Our Case Number: ABP-316119-23

Re: DART+ South West Electrified Heavy Railway Order - Hazelhatch & Celbridge Station to Heuston Station,
and Hesuton Station to Glasnevin
County Dublin and County Kildare

Observation on a Strategic Infrastructure Development Application

WORKS LAYOUT PLAN
KYLEMORE TO INCHICORE WORKS
SCALE 1:1250 (@A0)

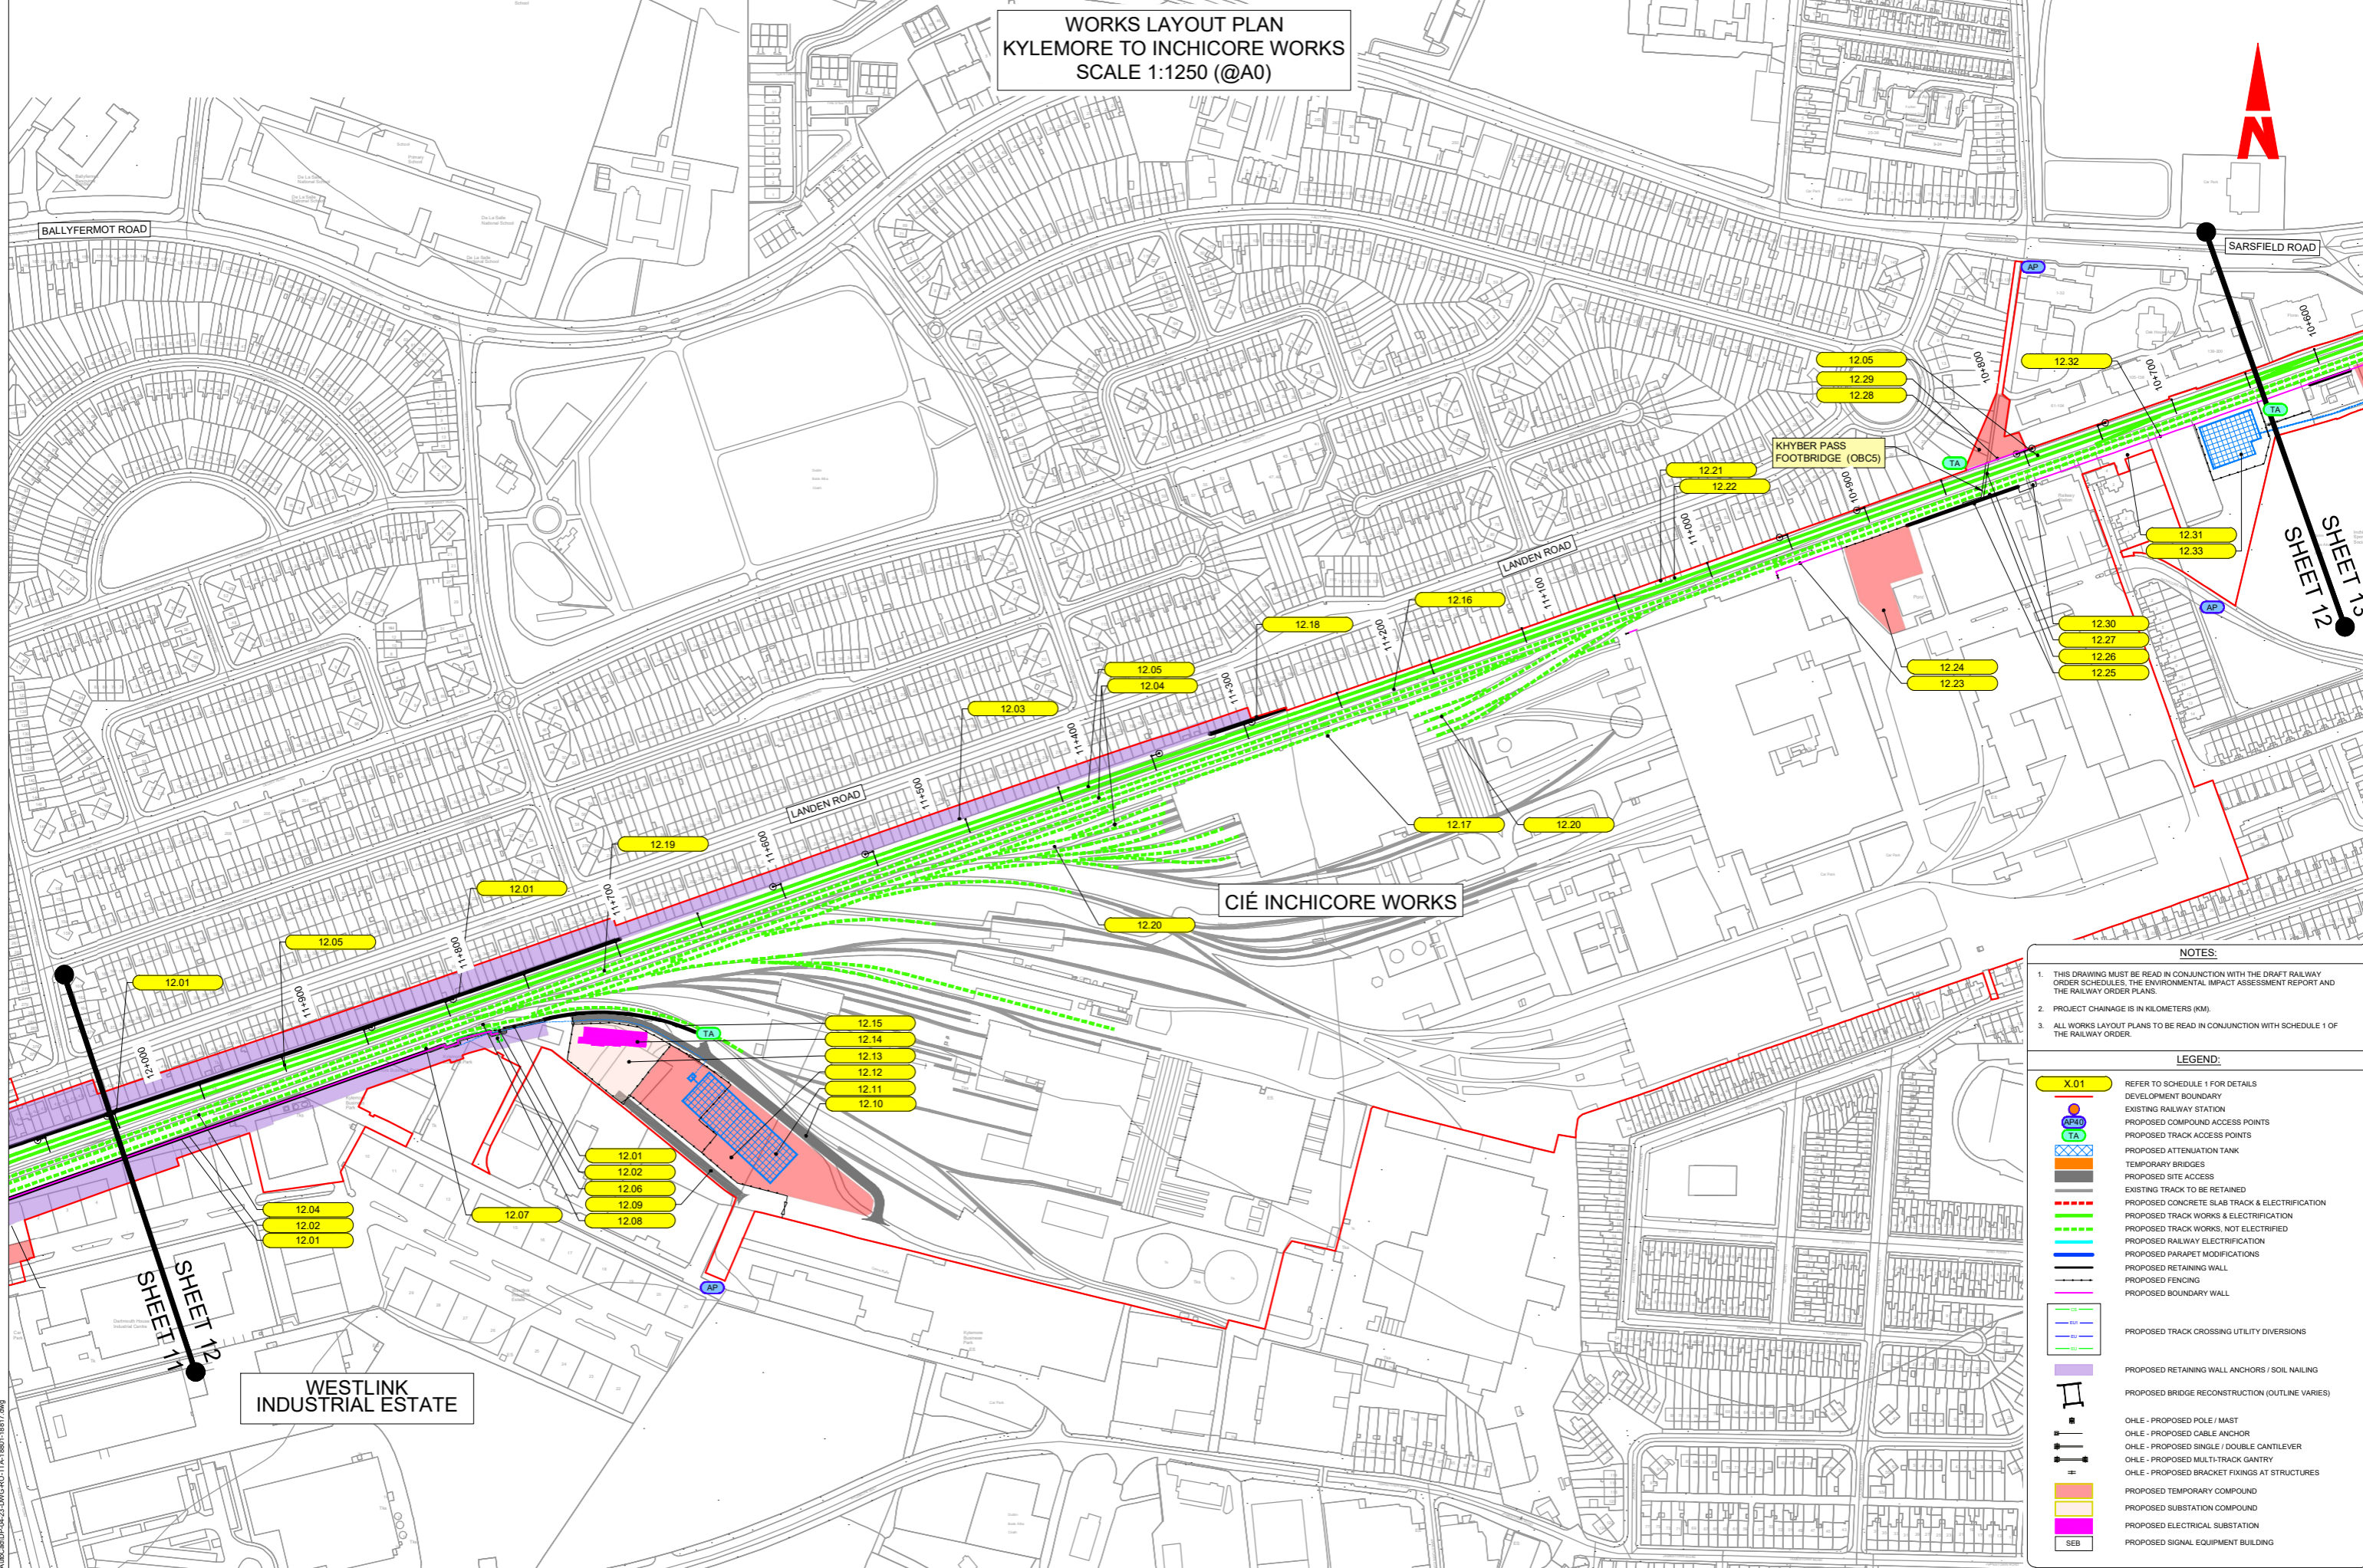
1. There is no station planned to serve Ballyfermot incorporated in the delivery of this proposed DART line. The plans indicate no station between the new Heuston West Station (to serve the community of

Clancy Quay and Island Bridge) and Parkwest - a distance of over 5kms (refer google map extract), when station interval cadence on for example the Dublin City to Dun Laoghaire Dart Line is every 1 to 2kms. Lack of delivering critical infrastructure to lower socio-economic neighbourhoods has been a known failure of planning and government in Ireland for several decades, the mistake of further bypassing and 'ghettoising' Ballyfermot should not be made again here in delivering this piece of rail infrastructure. It is beyond the spirit of good planning in this age of integrated climate action to bypass a whole suburb with an electrified line and not provide access to locals.

A station at Kylemore bridge should be conditioned as part of delivering these works.

2. Loss of quiet enjoyment of mine and other gardens and residences bordering rail line. The intended several-fold increase in rail traffic will adversely affect residents of Landen Road, Ballyfermot, especially those terraces along south of Landen Road which border this proposed rail corridor. Effects of both airborne and ground noise across the full spectrum of low to high frequency, during and after construction should be minimised to best practice. Noise mitigation of proposed DART line should be designed with reference to techniques of sound damping and sound absorption as well as sound screening measures. Visual nuisance of loss of privacy due to overlooking from trains is also an adverse aspect of this development and should be properly considered by the design team.

10. Four-tracking of the rail line from Park West & Cherry Orchard Station to Heuston to enhance capacity brings the existing rail tracks closer to rear boundaries along Landen Road, have other options or further encroaching southwards on IE land not been considered?
